**Consultation Response from KC,
Lead Local Flood Authority**

2026/91649 The Coach & Horses, Eastgate, Honley, Holmfirth, HD9 6PA

Discharge of details reserved by conditions 8 (access signage/white lining markings), 15, 16, 17 (drainage), 18 (crime/security), 19 (landscaping), 20 (materials), 22 (windows), 23 (doors) on previous permission 2025/93126 for demolition of rear block, erection of rear extensions and alterations to existing building to form 9 apartments including associated works and alterations (within a Conservation Area)

Discharge of Drainage Conditions

| Title | MHS04 Hydrobrake Manhole Detail |

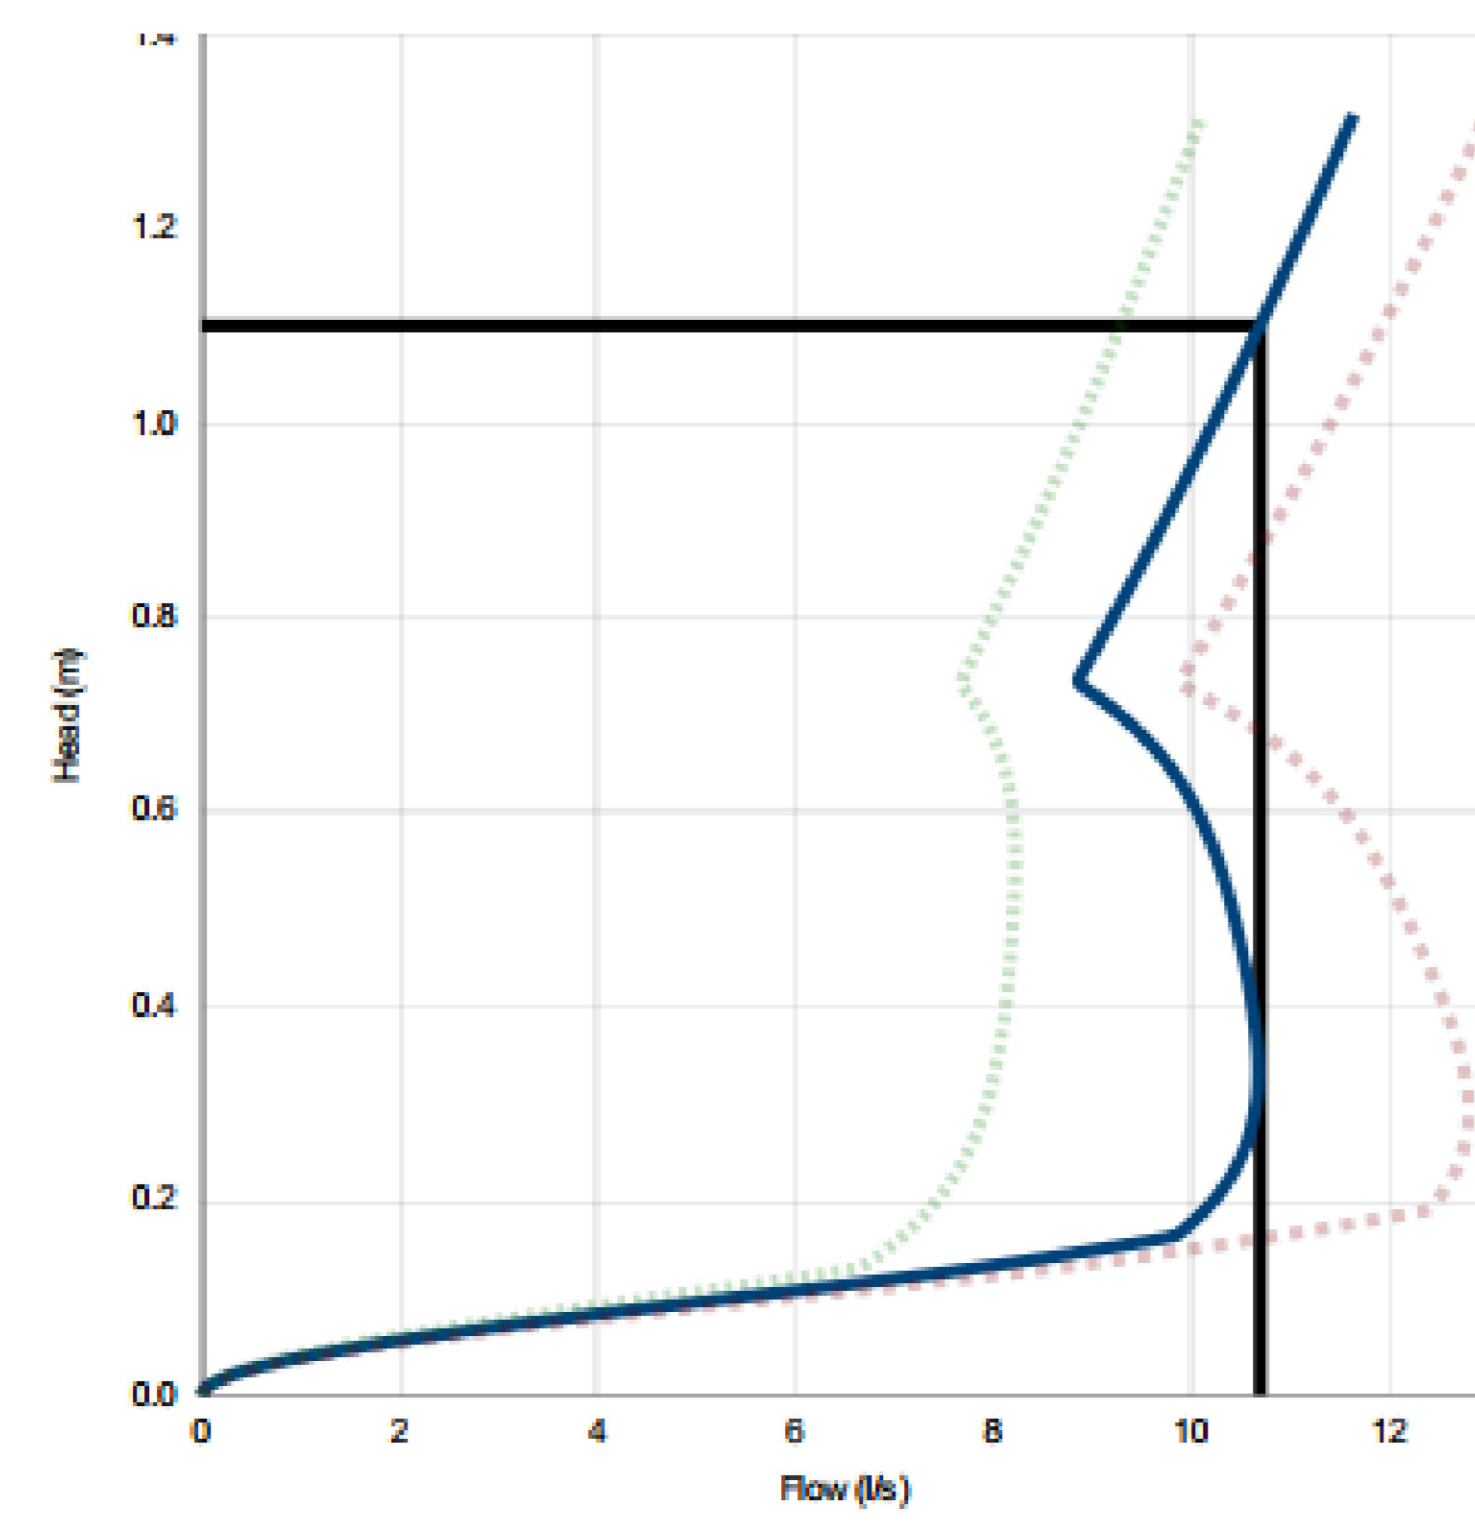
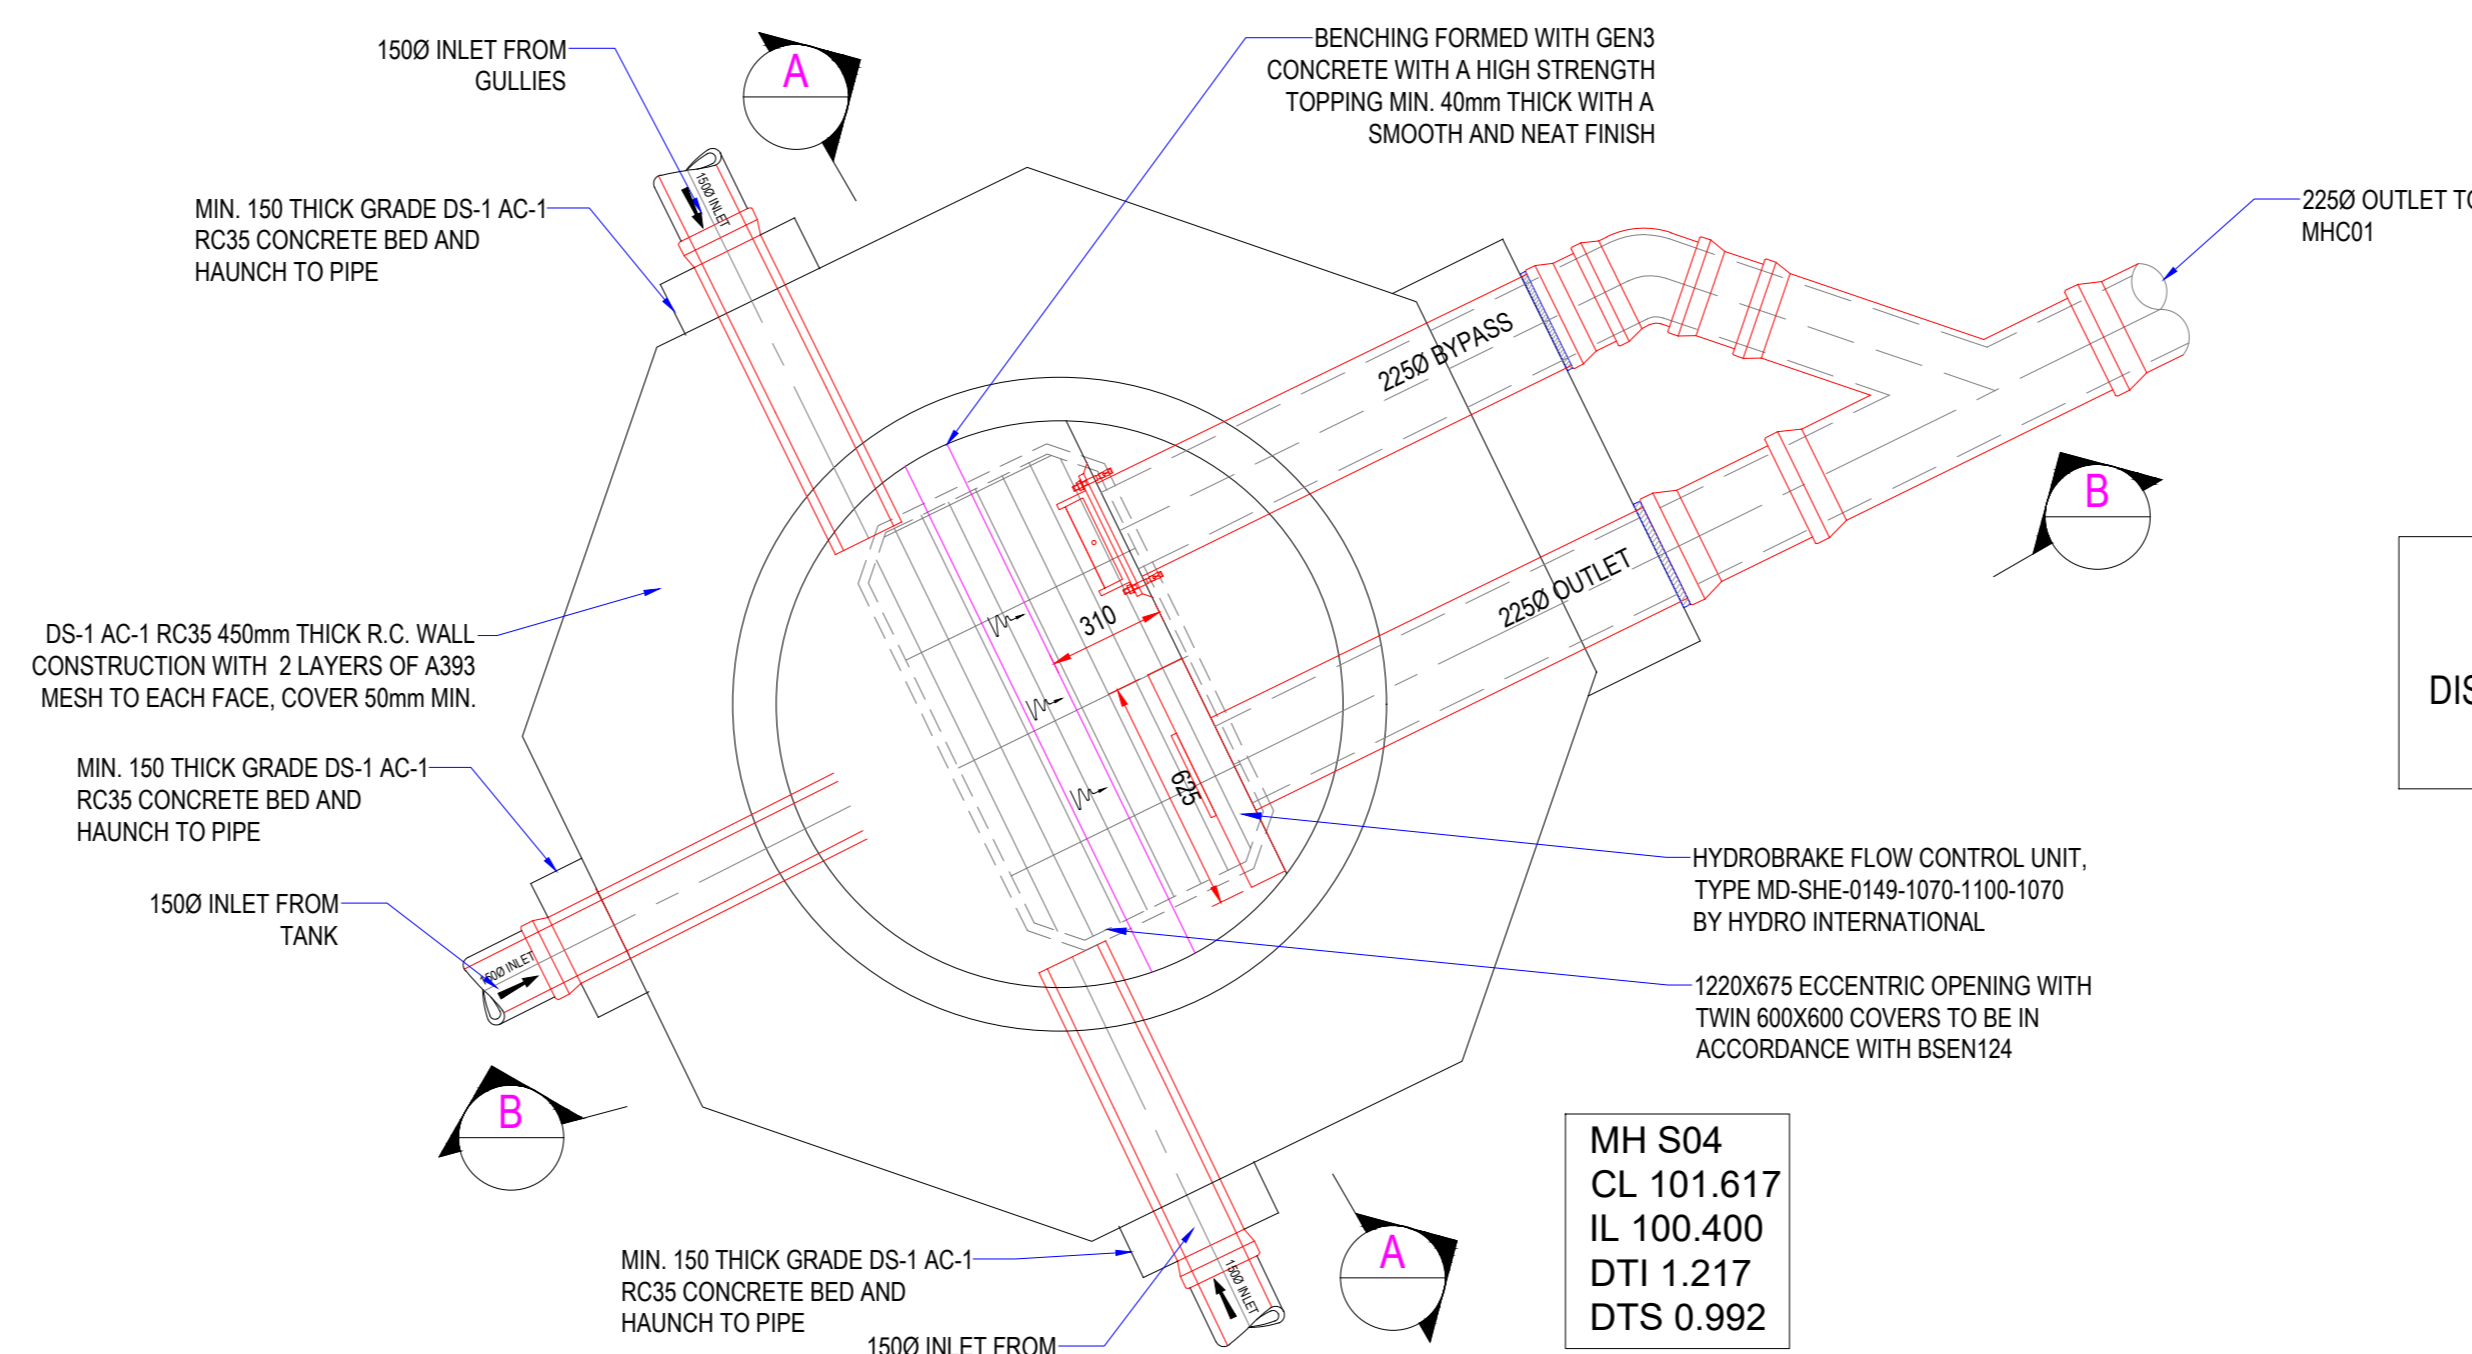
The LLFA confirms that the Drainage Strategy is accepted including the allowable surface water discharge rate of 10.7 l/s together with the hydraulic calculations. However, the remaining requirements of Condition 17 have not been addressed.

Therefore Condition 17 **cannot be** discharged until the remaining details has been sent to the LPA for approval.
